REPORT UPDATE

Application No: BN/96/25/PL

LOCATION: Land West of Brookside
Highground Lane

PROPOSAL: Demolition of existing barn to be replaced by a new barn within the existing footprint. This application is in CIL zone 3 (zero rated) as other development. This may affect the character and appearance of the Church Lane, Barnham Conservation Area.

DRAWING
**PROPOSED PLAN & ELEVATIONS -
BARN**

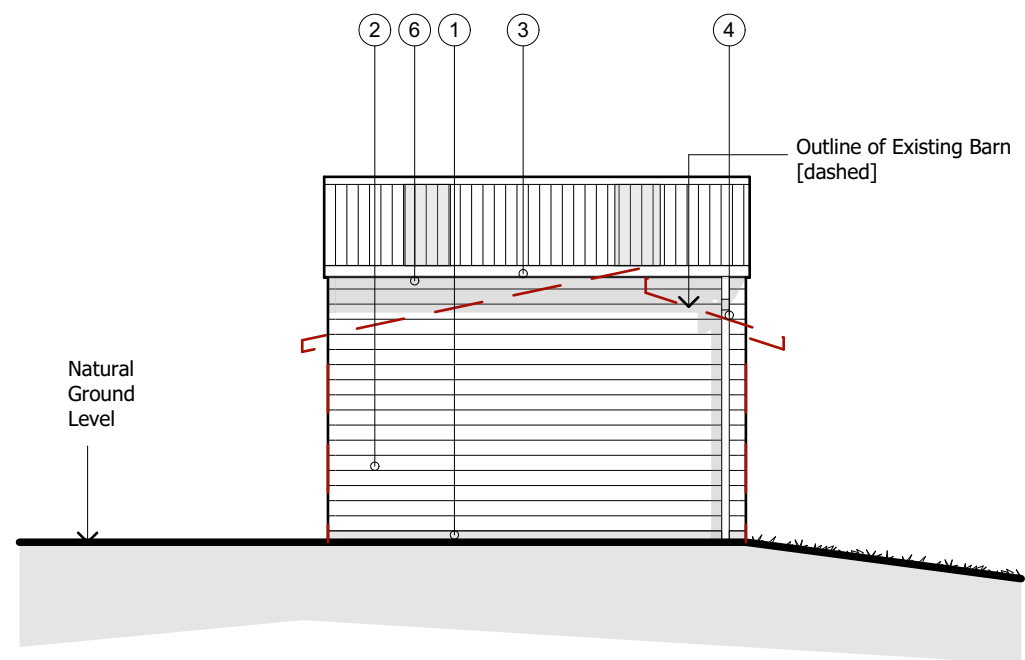
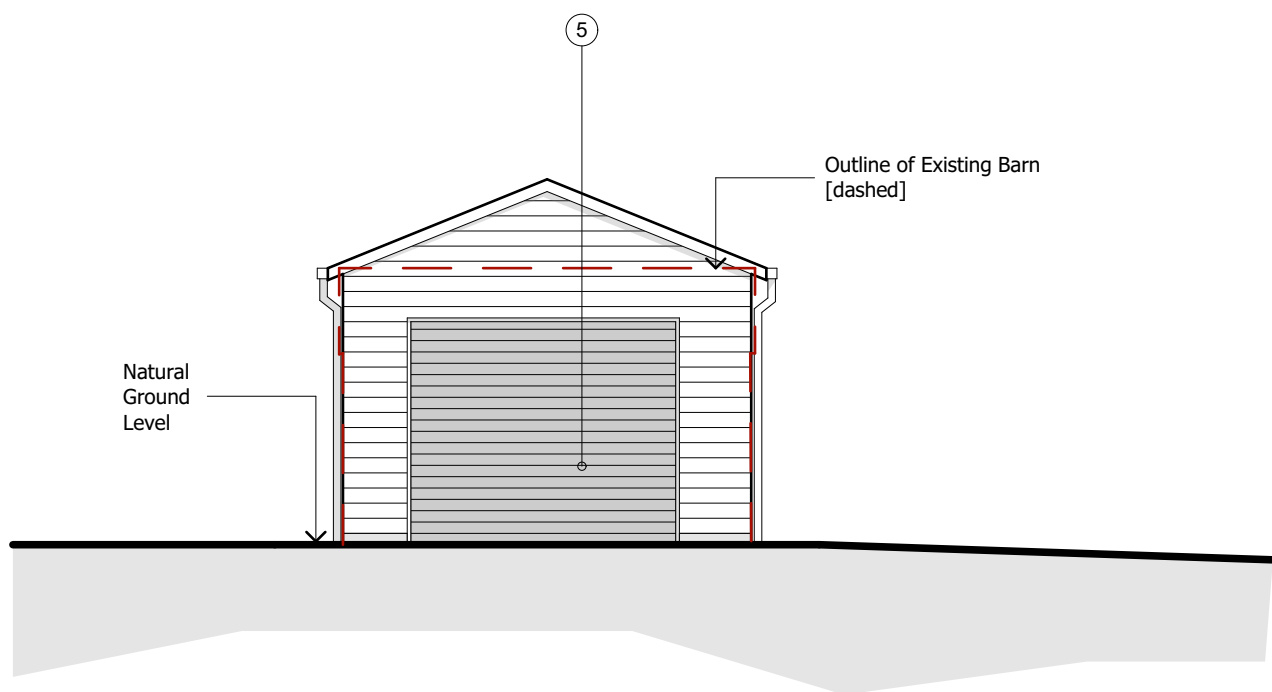
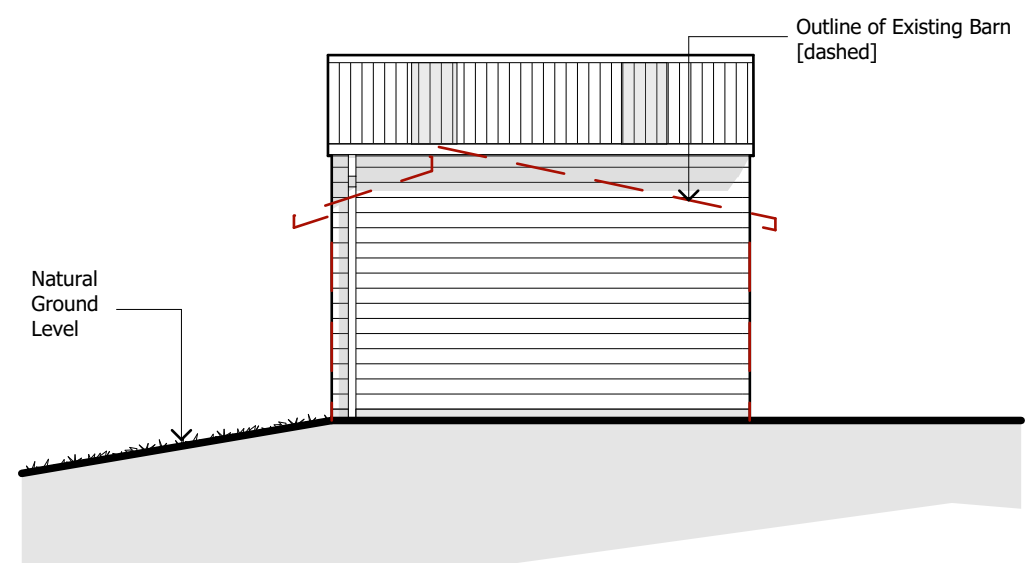
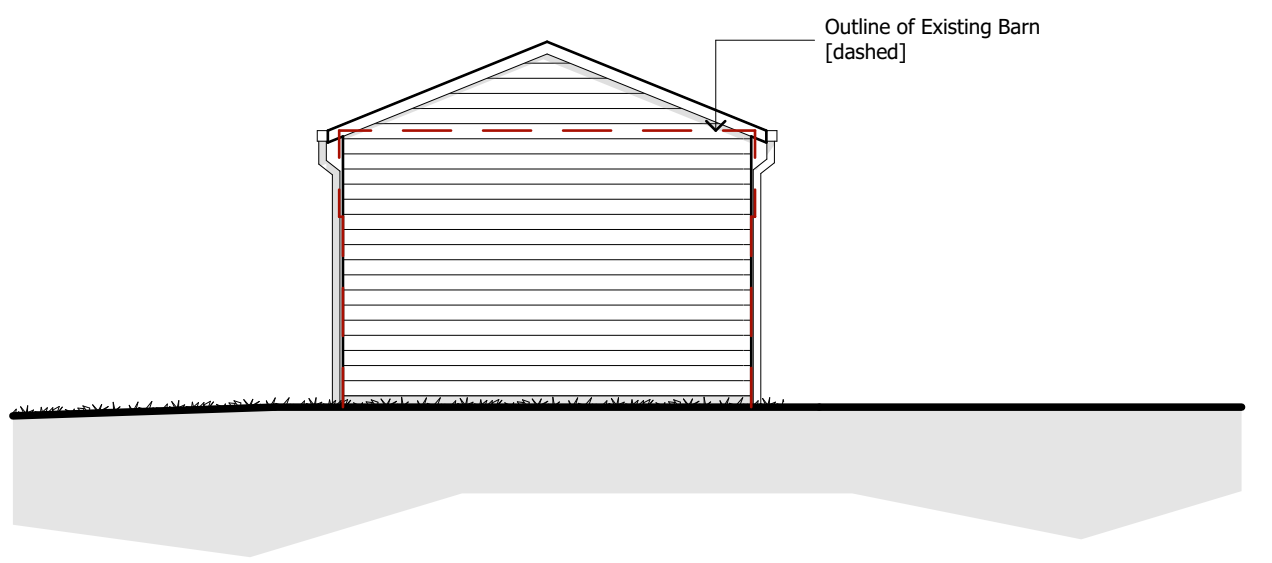
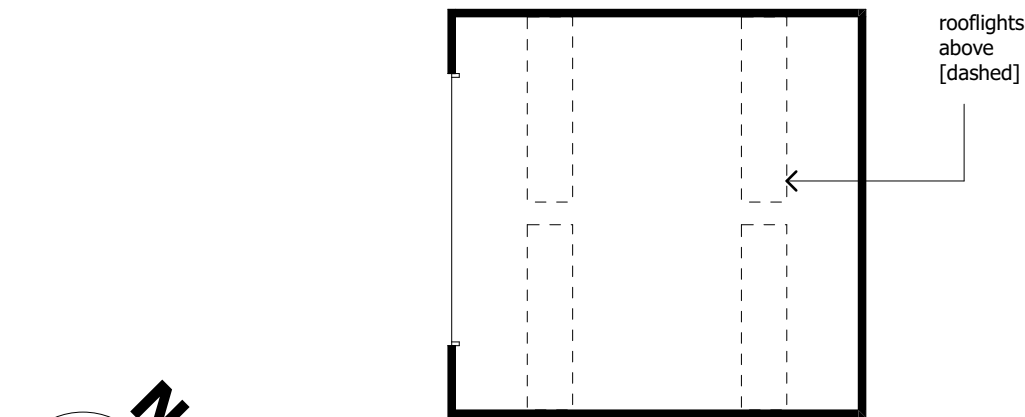
Consultation comments were received from ADC drainage engineers in which they object on the basis there is insufficient information to evidence that flood risk will not be increased due to the proposed development. At present insufficient detail has been included on the drainage plans submitted for engineering assessment.

The barn measures 5.5m x 5.4m and this matches the footprint of the existing building. The proposed barn would be taller at 4.8m with eaves to 3.6m, an increase of approximately 1.2m with a pitched roof.

The barn is of a standard construction and would result in a visual appearance that would remain largely as existing, albeit a slight alteration to the shape of the roof. The barn would be clad in horizontal timber with a brick plinth and a profiled metal roof. The materials would be appropriate for the site and wider area.
